KITTITAS COUNTY COMMUNITY DEVELOPMENT SERVICES

RE: Swauk Valley Conservation Short Plat (LP-17-00007) - Request for Additional Information

RE: Swauk Valley Ranch LP-17-00007

RE: WDFW comments on LP-17-00007 Swauk Valley Ranch Long Plat Application

SWAUK RANCH CONSERVATION PLAT

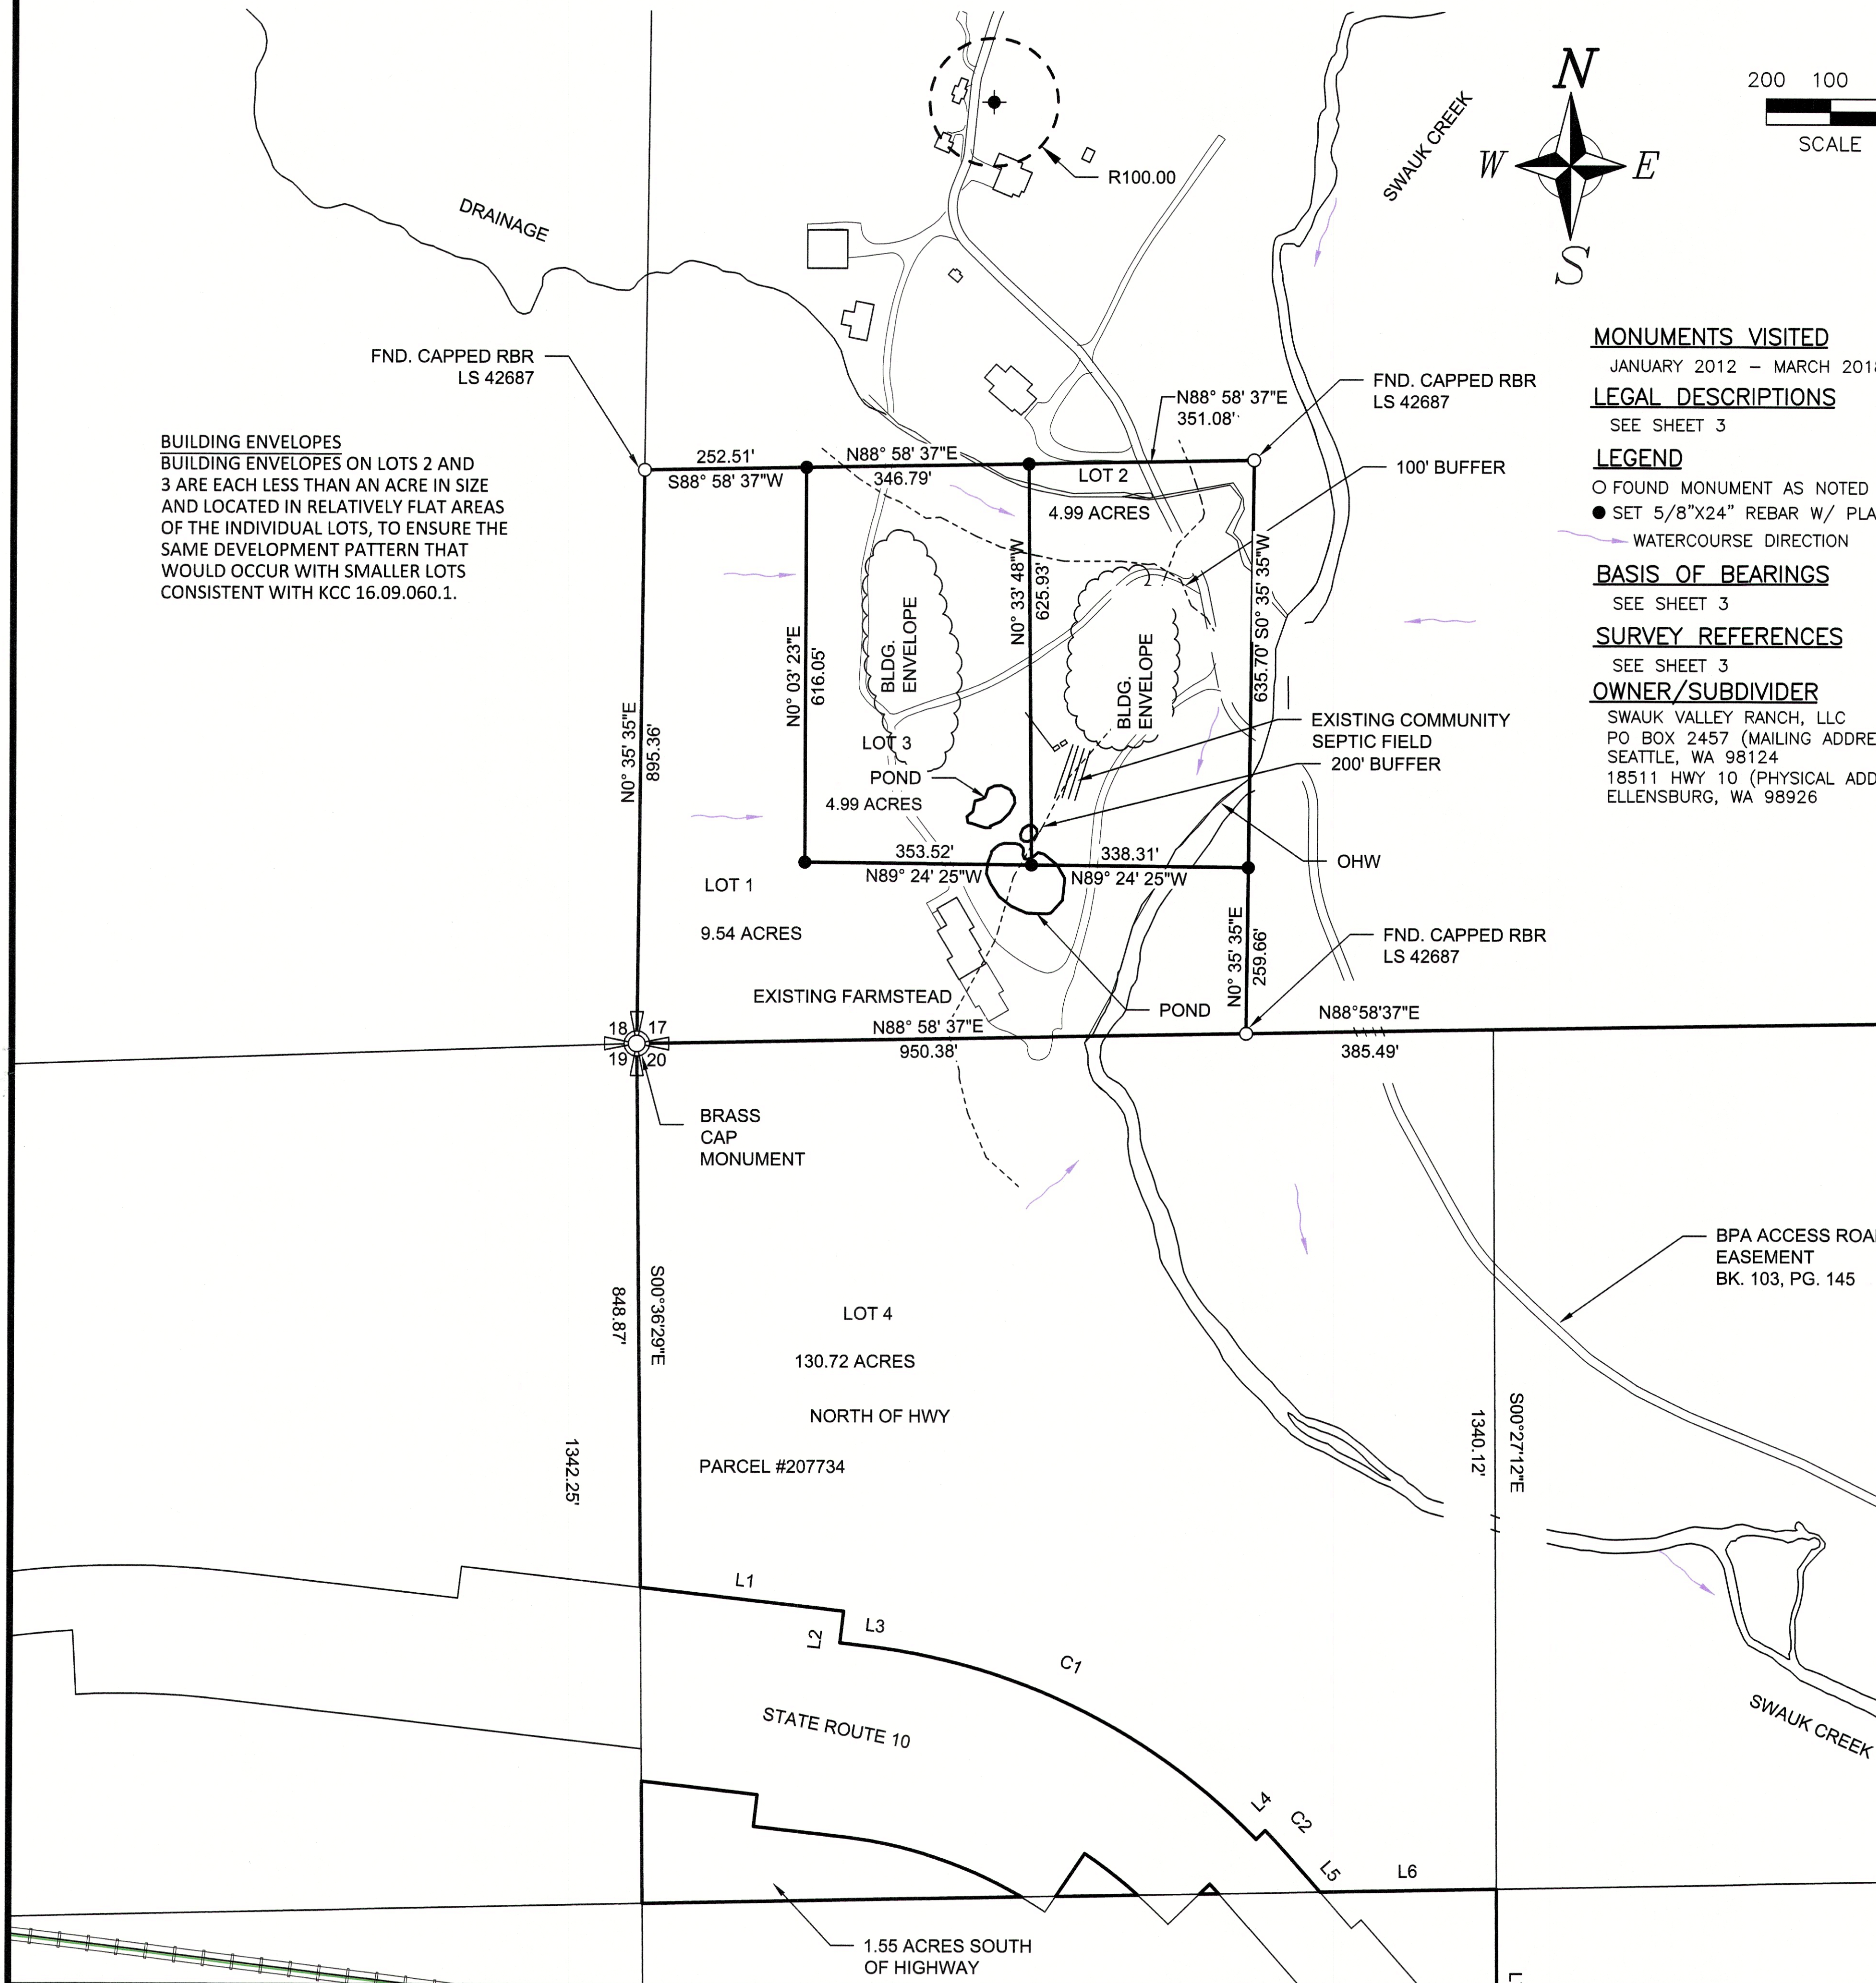
2. A revised plat drawing showing shoreline buffers and ordinary high water marks, critical areas buffers, and their locations in relation to the building envelopes as per the Kittitas County Shoreline Master Program 5.2(C)(3).

An unnamed tributary stream flows from the west toward Swauk Creek through the northern portions of the new lots; particularly lot 2. Both lots 2 and 4 may have portions within the Shoreline buffer of Swauk Creek and its channel migration zone. Please clearly show where the buildable areas will be within the new lots (including septic) prior to approval. Buildable areas should take into consideration the current critical area and shoreline buffers and setbacks, knowing that buffer widths may change in the future, and the buildable areas could change as

The unnamed, fish bearing tributary to Swauk Creek is not identified in the survey. This aerial photo with the stream layers is taken from the County's Assessor's site and the location of the streams is slightly inaccurate. The tributary probably actually flows closer to the northern boundary of lots 2 and 3. The critical areas and their buffers should be field verified and recorded on the survey prior to approval of the short plat and building envelopes.

SHEET 2

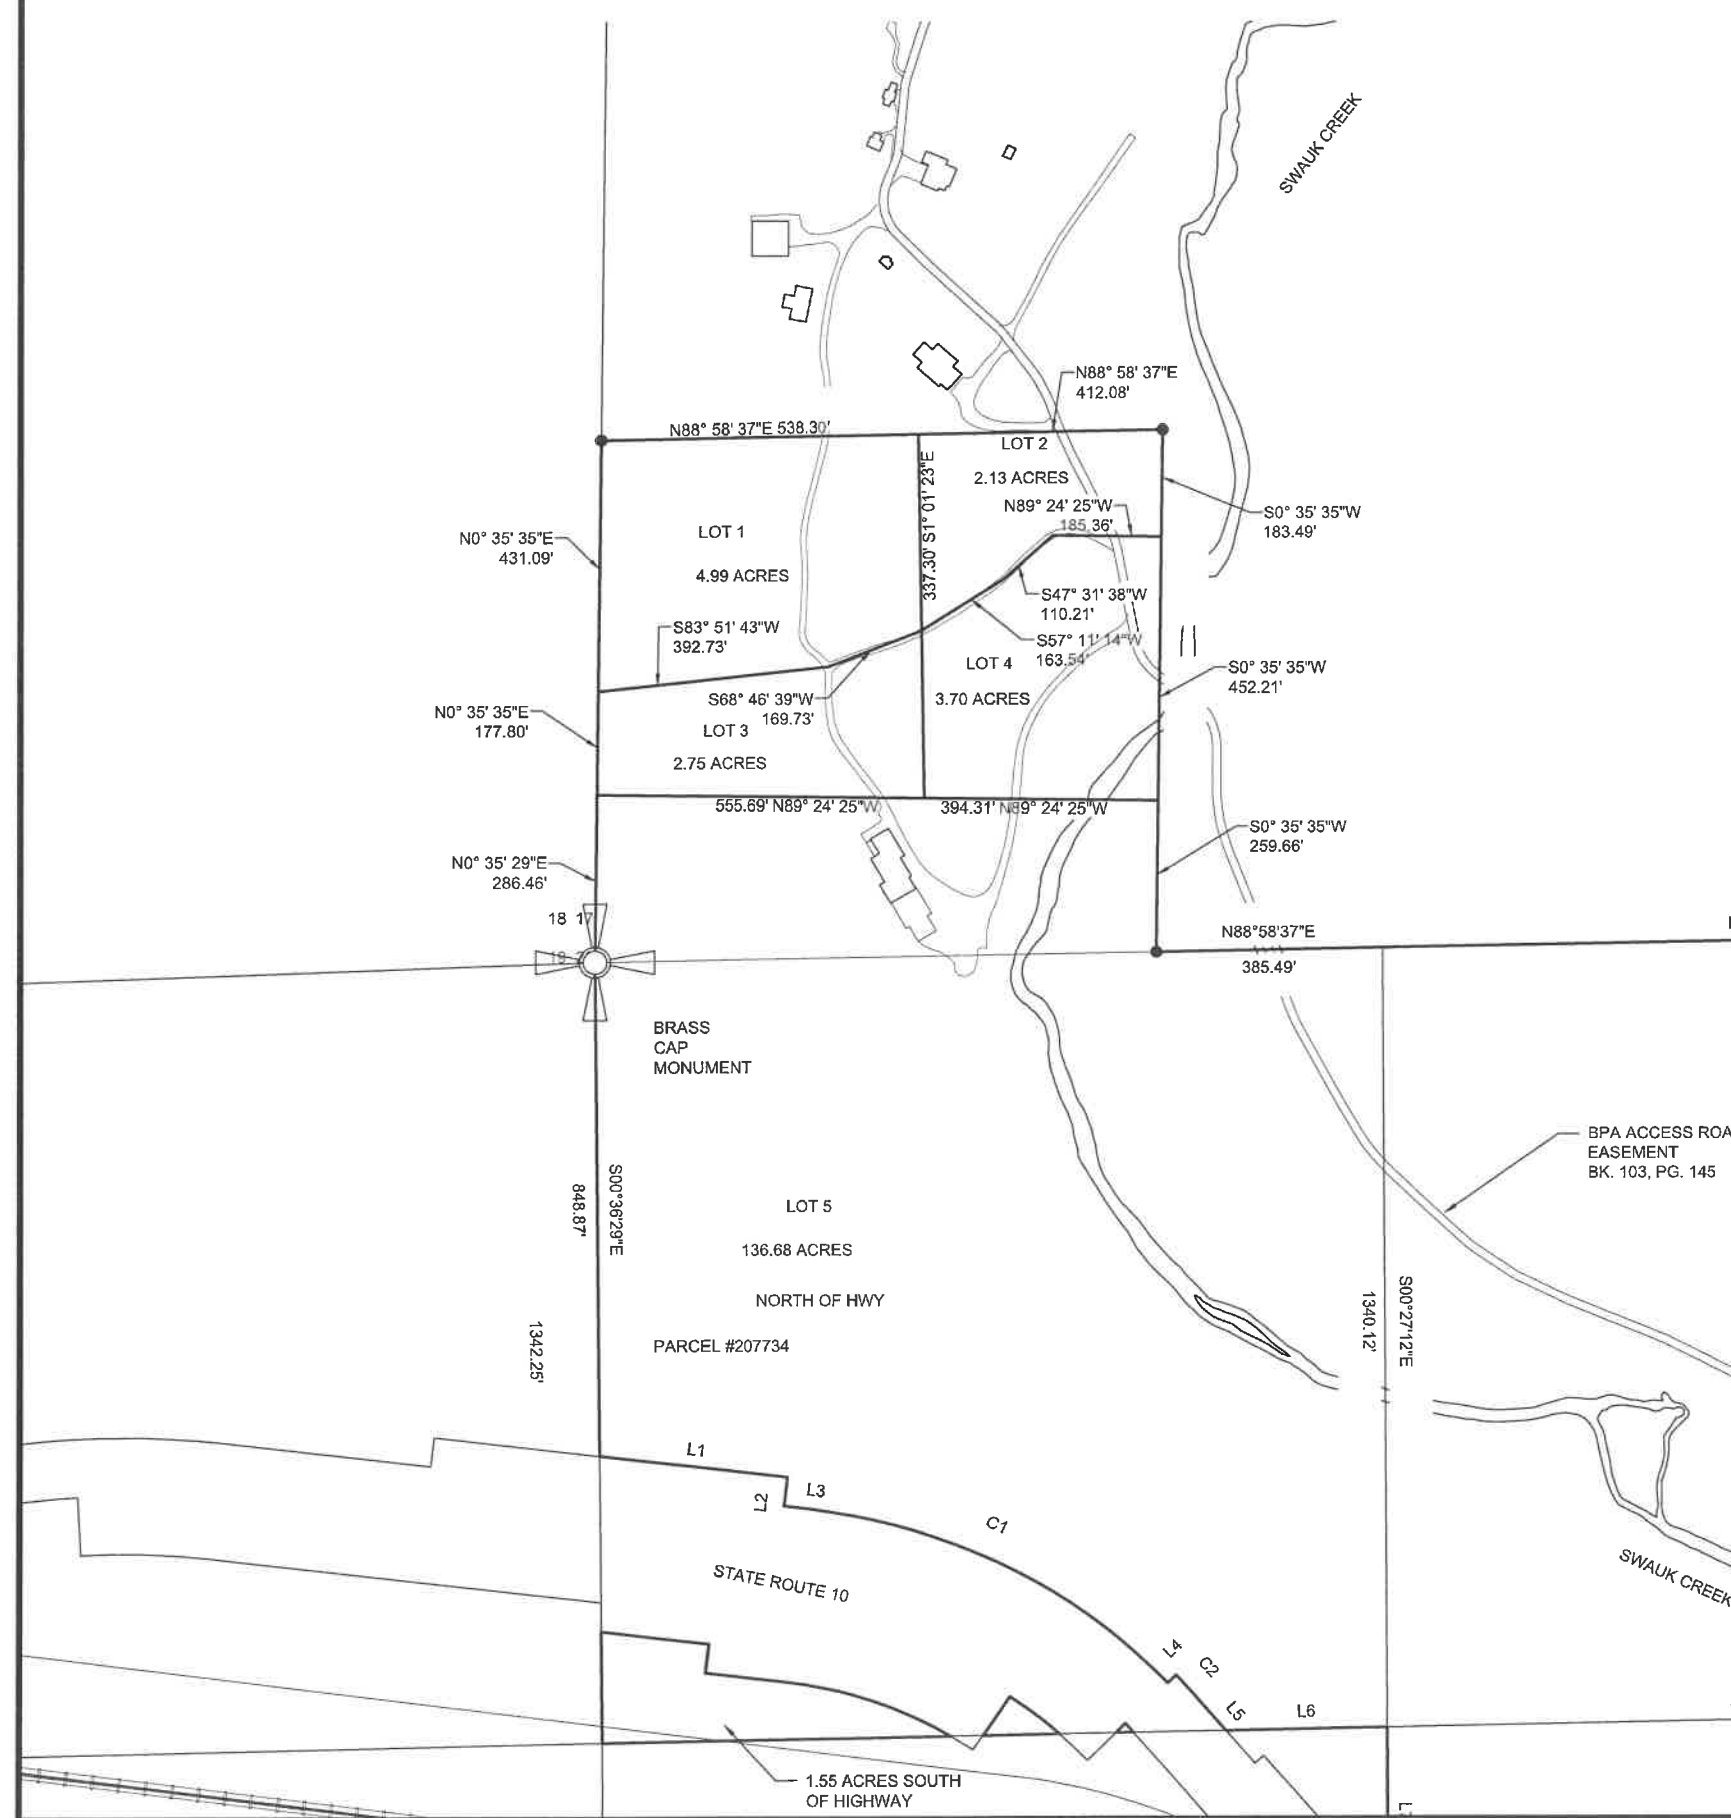
The maps attached with this land use action do not seem to reflect the recent boundary line adjustment (BL-16-00012), making it difficult to determine where the new parcels will actually be as they seem to be north of the mapping shown. We have done our best to determine approximate new lot lines as they will pertain to fish and wildlife resources, but request updated mapping showing the proposed lot lines and their relation to critical areas, shorelines, channel migration zones, and priority habitats for a better analysis.

We strongly urge a revised site plan that shows the buffer and setbacks areas associated with all of the critical areas and Shoreline of Swauk Creek in order to evaluate future buildable areas prior to approval of this short plat. We'd also like to see a wetland delineation and critical areas report to ensure there are no other critical areas within the proposed short plat that would be impacted by future development, including the installation of septic systems and potential impacts on water quality.

Vegetation shifts and hydrologic signatures, most notably within the canyon, suggest riverine wetlands are likely present surrounding Swauk Creek. Per Section 5.2.C.3 of the County's SMP, applicant's proposing new land-uses or development within the shoreline need to provide the following critical area information: presence, location, condition, and vegetated buffer which could be affected by their proposal. The Department of Ecology (Ecology) recommends a formal wetland delineation and rating be performed prior to any construction, as this could impact the amount of buildable area available.

In addition to any required vegetative buffers, structures are to be setback an additional 15 feet from the edges critical area buffers (or critical area edges if buffer is not required).
